From: Daniel James [REDACTED]
Sent: 21 June 2018 11:26
To: Planning
Subject: Application_Ref_No=AL/40/18/PL

Ref: Planning Application AL/40/18/PL
To whom it may concern:

I STRONGLY OBJECT to the proposed development on the land adjacent to 14 St Johns Close, Westergate, Aldingbourne, PO20 3TH by Arun District Council (c/o MH Architects Ltd.

location plan &
proposed site plan

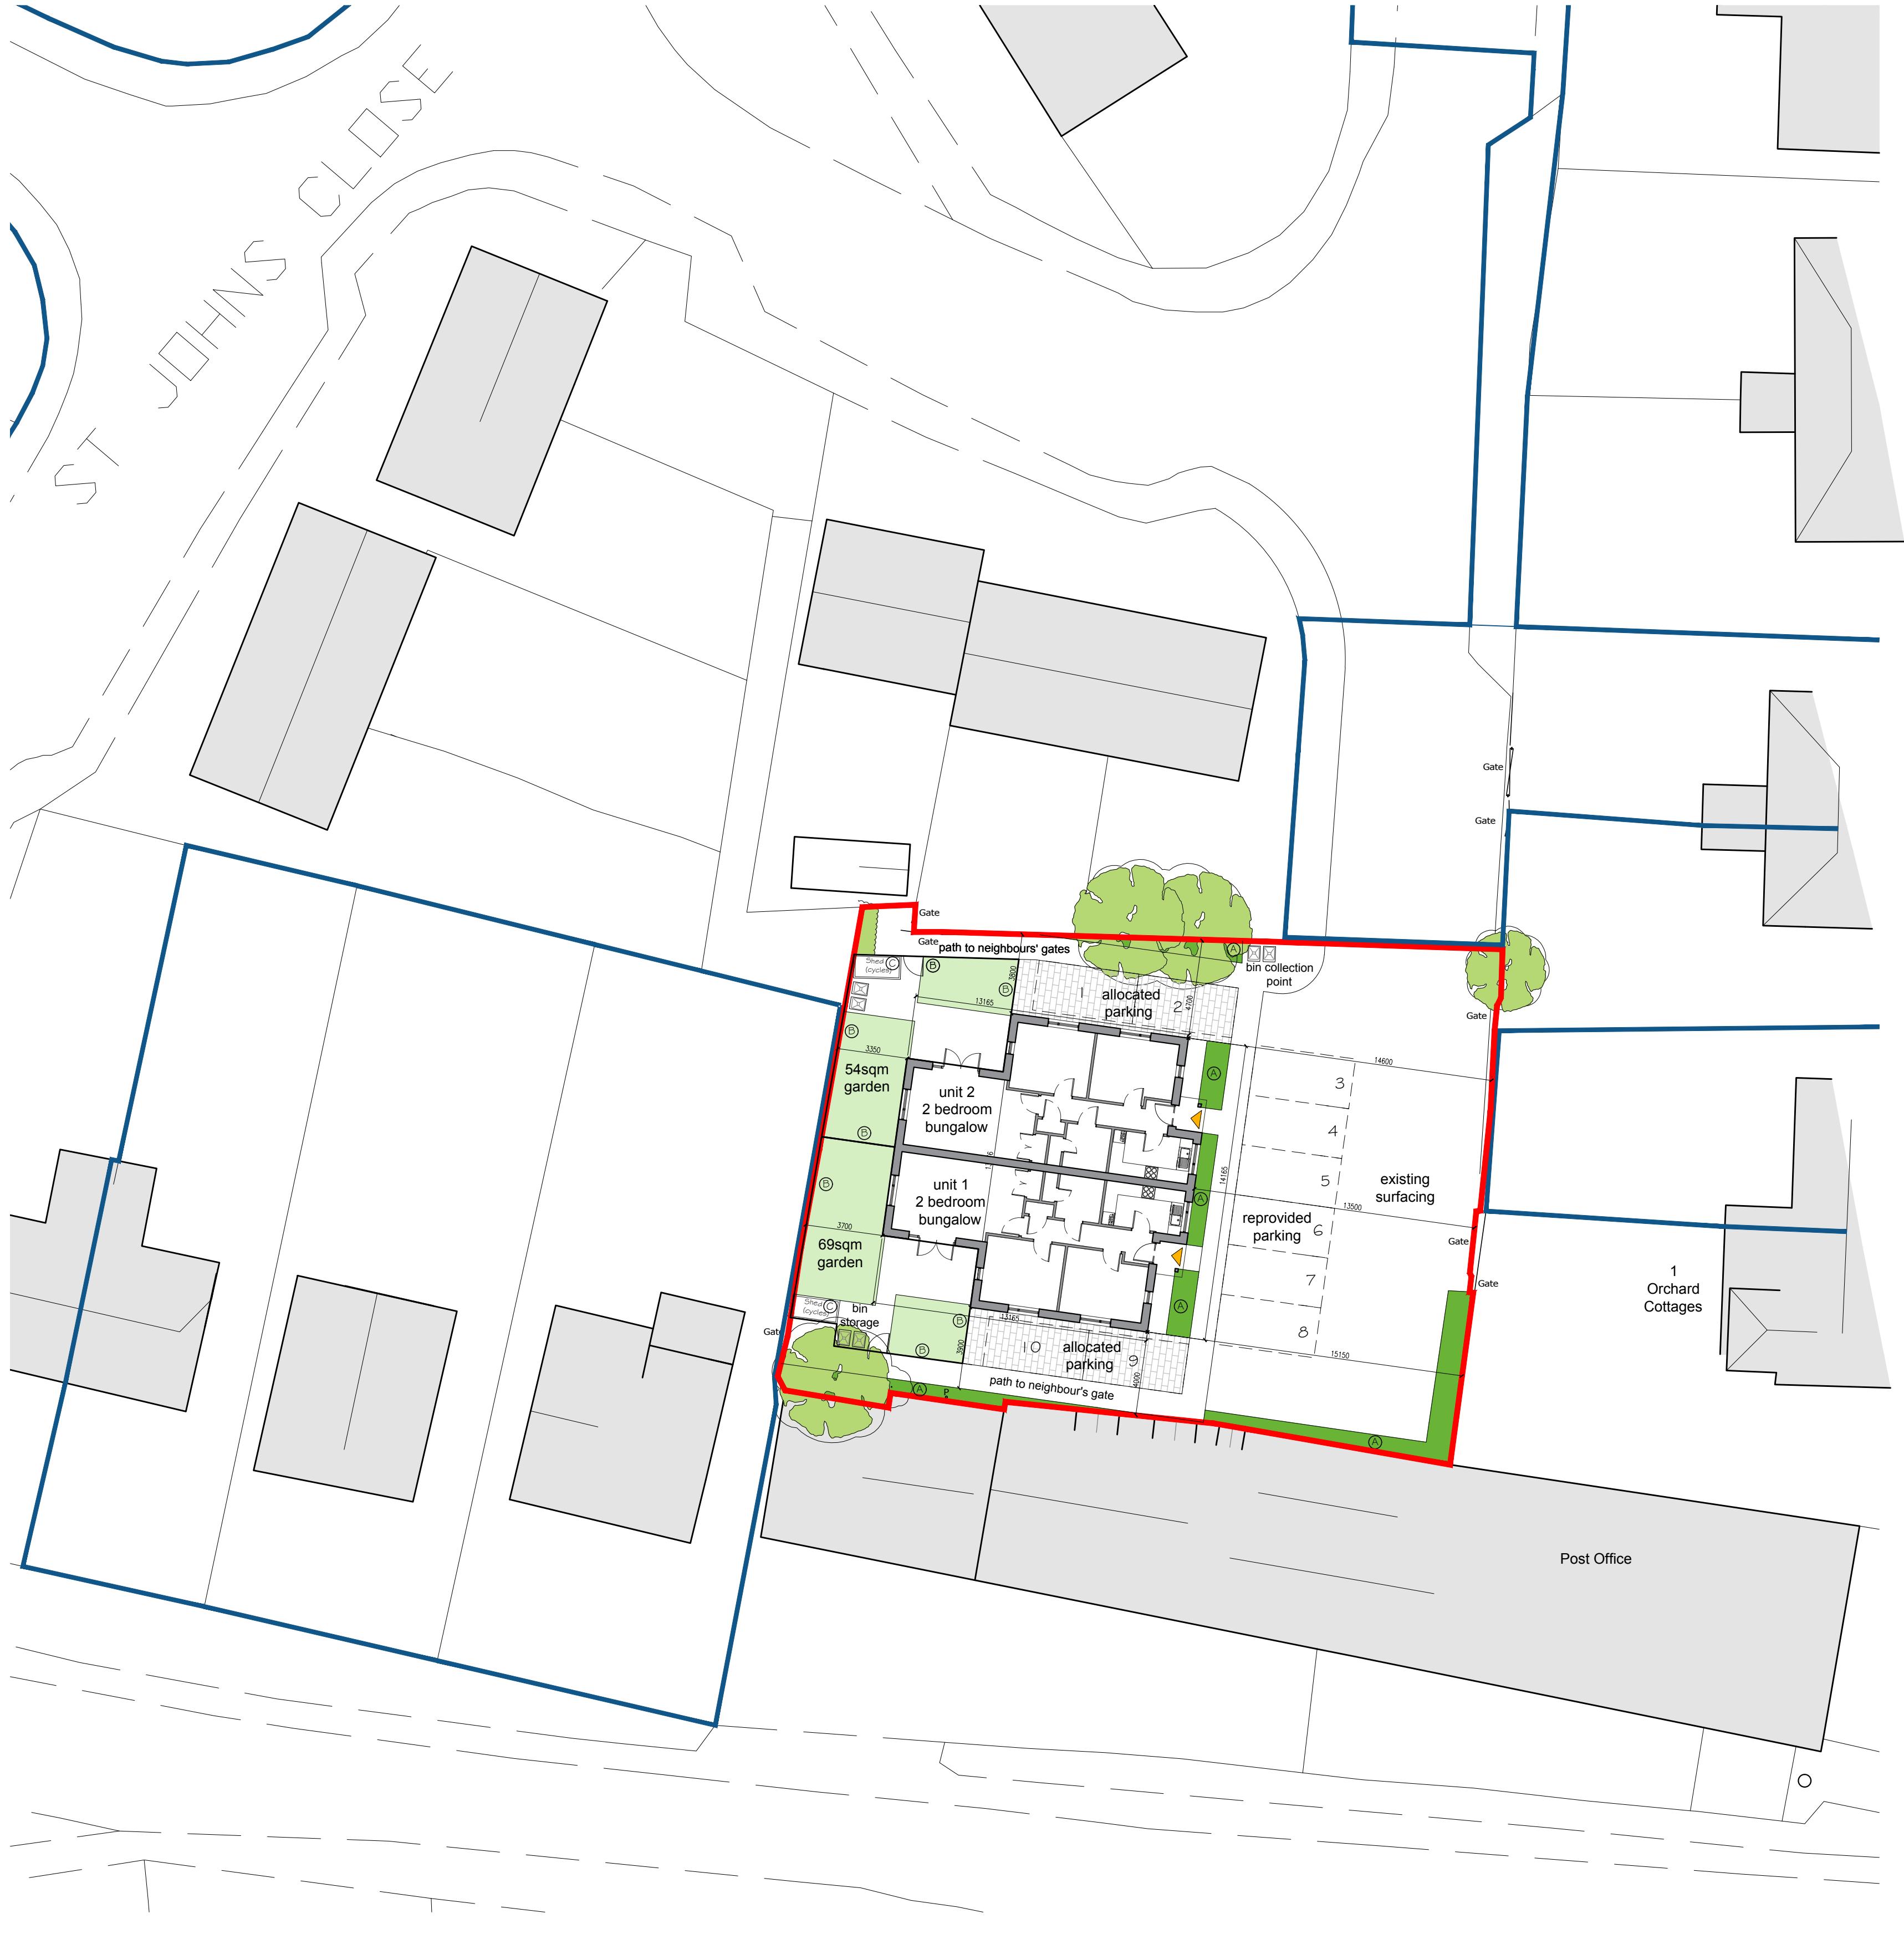
Furthermore I am concerned that there is in fact a sewer running across the site.

From looking at the plan, part of the area the rear of 3 Orchard Cottages has been allocated as re-provided parking. We have 2 young children and not being able to park to the rear of our property will increase the risk of them being put in danger and cause us all a massive inconvenience.
